Project Name:	Moran's Market	Project ID:	2017-251
Address:	1576 Forest Avenue	CBL:	299 D001001
Applicant:	Bernard and Peter Larsen

On November 2, 2017, the Planning Authority approved with conditions an administrative authorization application for site improvements at 1576 Forest Avenue, known as Moran's Market, in order to legalize a fourth residential unit. The decision is based upon the application, documents and plans as submitted. The proposal was reviewed for conformance with the standards of Portland's Site Plan Ordinance and Technical Manual.

Sheet Title:
**PARKING
PLAN**

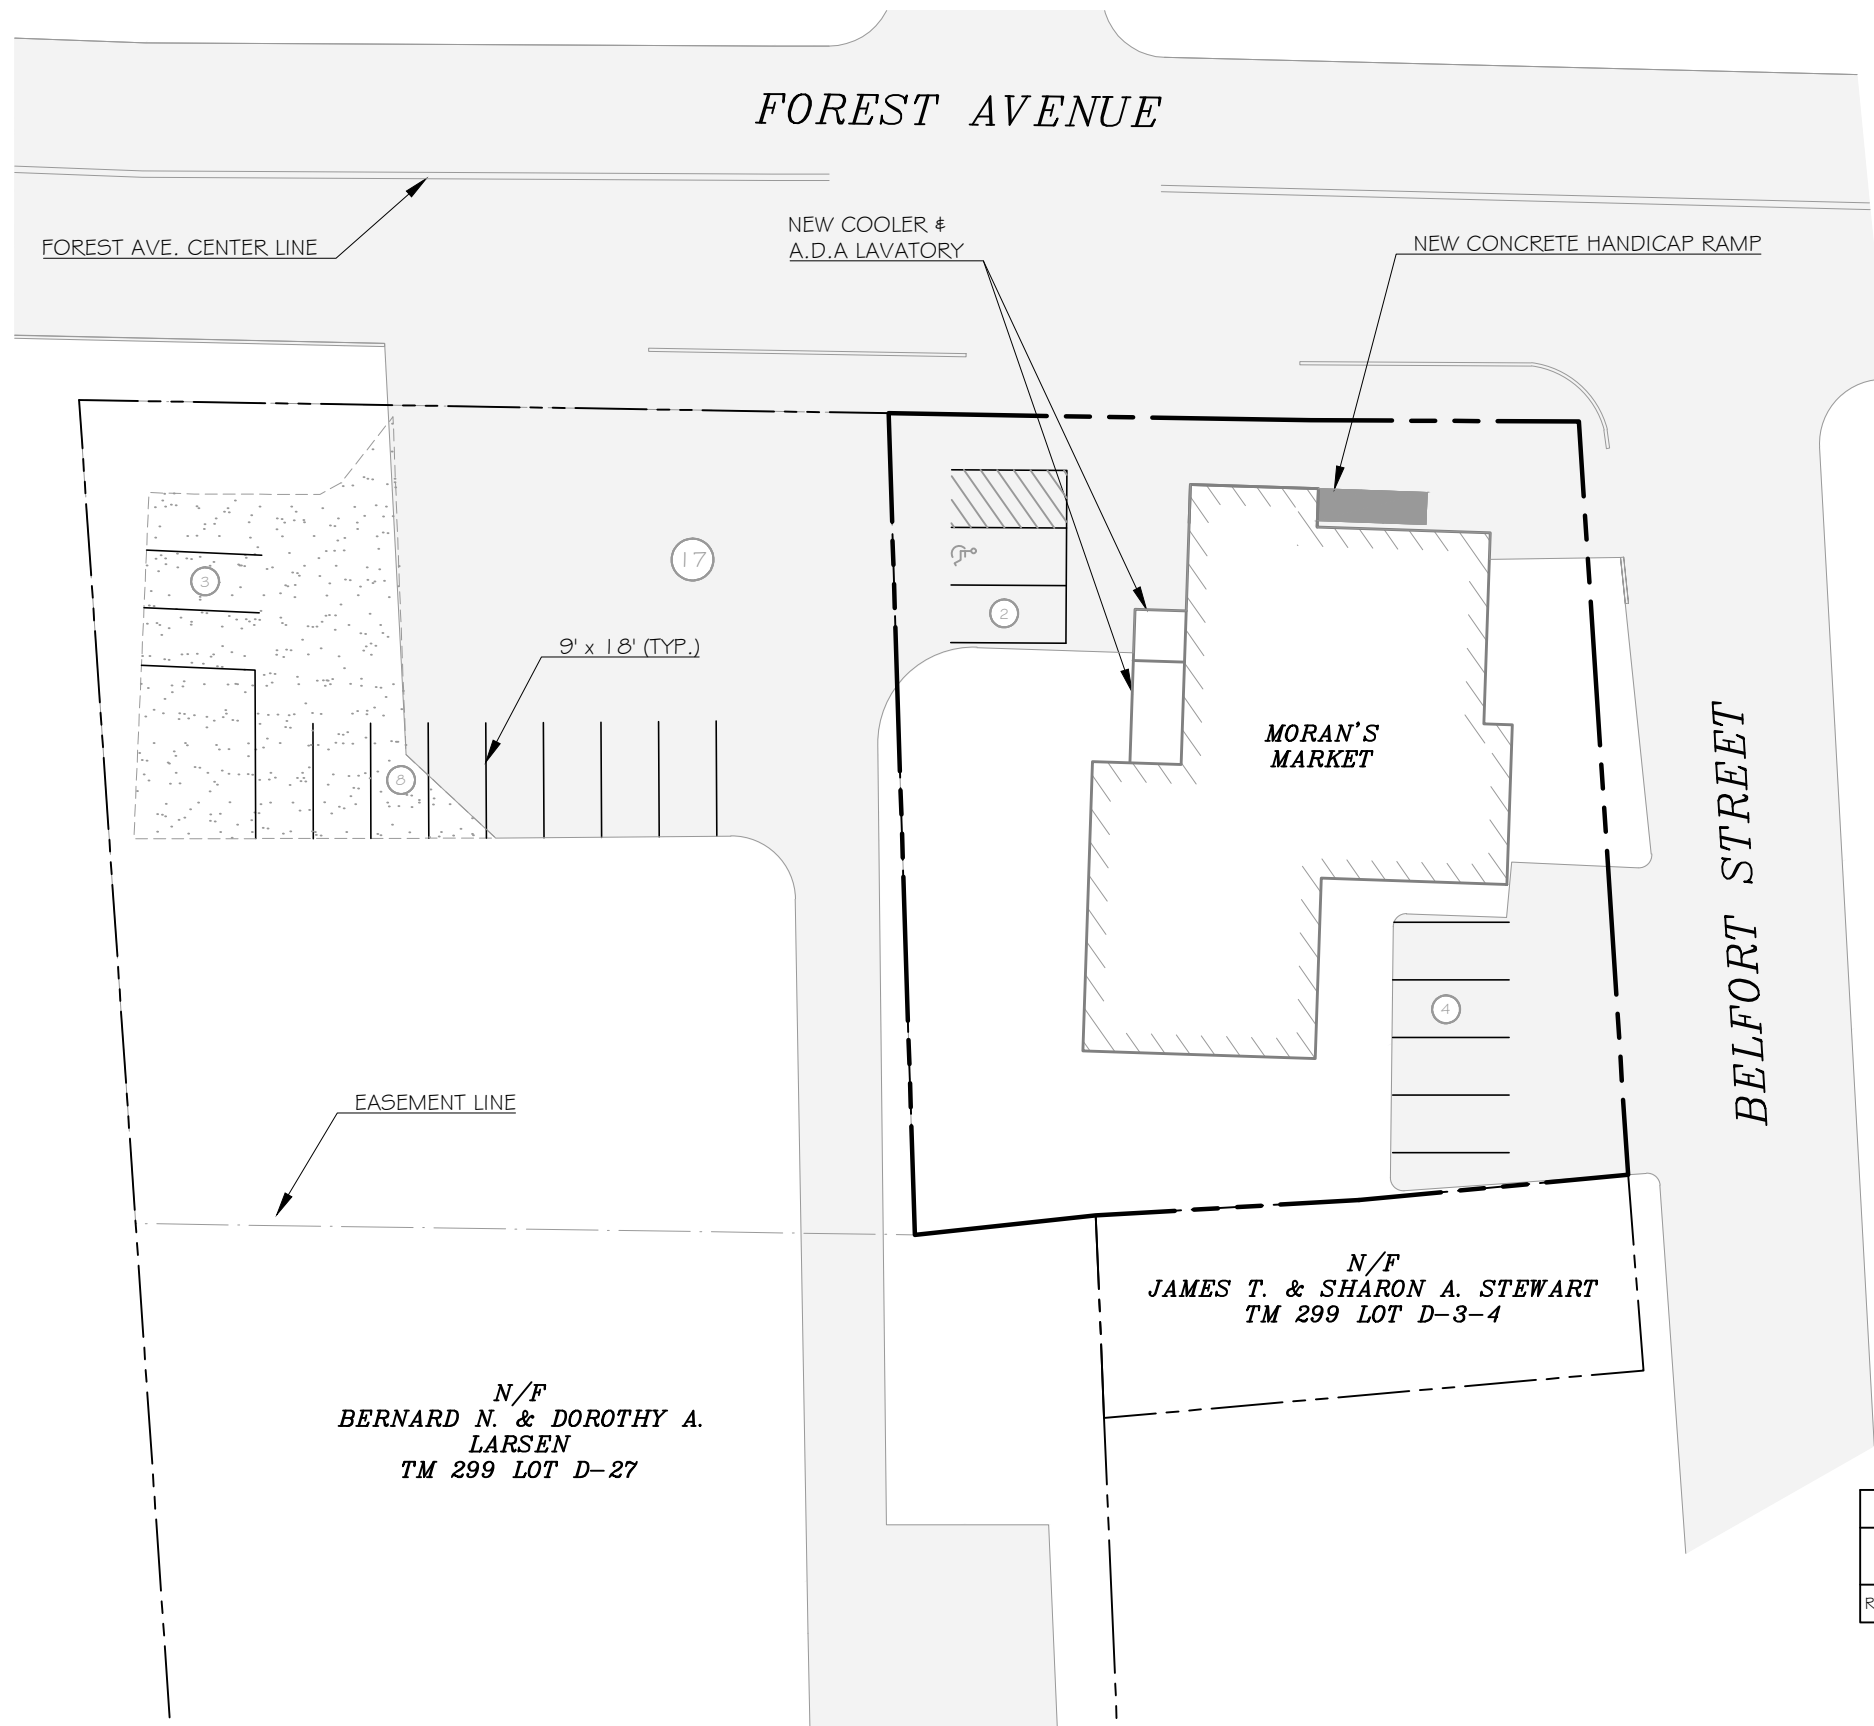
1. Placement of pinned curb stops and/or planters with spacing no farther than 10 feet apart and anchored to the ground and placed a minimum of 6' from the back of curb on the Forest Avenue side of the side, between the two Forest Avenue curb cuts and between the westerly curb cut and Belfort Street as shown below. Exact locations of curb stops may be adjusted based on consultation with Public Works staff in order to allow for safe access to the loading door;

2. Permanent installation of approximately 19 linear feet of vertical granite curb from the end of the catch basin curb inlet and matching the top of the curb reveal at the curb ramp tip-down curb stone along Belfort Street at its intersection with Forest Avenue. This curbing shall be installed by a contractor licensed by the Department of Public Works to do such work, as shown below on page two, and the sidewalk shall be regraded to meet Americans with Disabilities Act standards;

3. Provision and annual maintenance of painted lines, similar to a crosswalk, across the Forest Avenue curb openings to delineate the parking areas from the public sidewalk. Precise locations of these lines will be determined with consultation from Public Works or Planning division staff; and
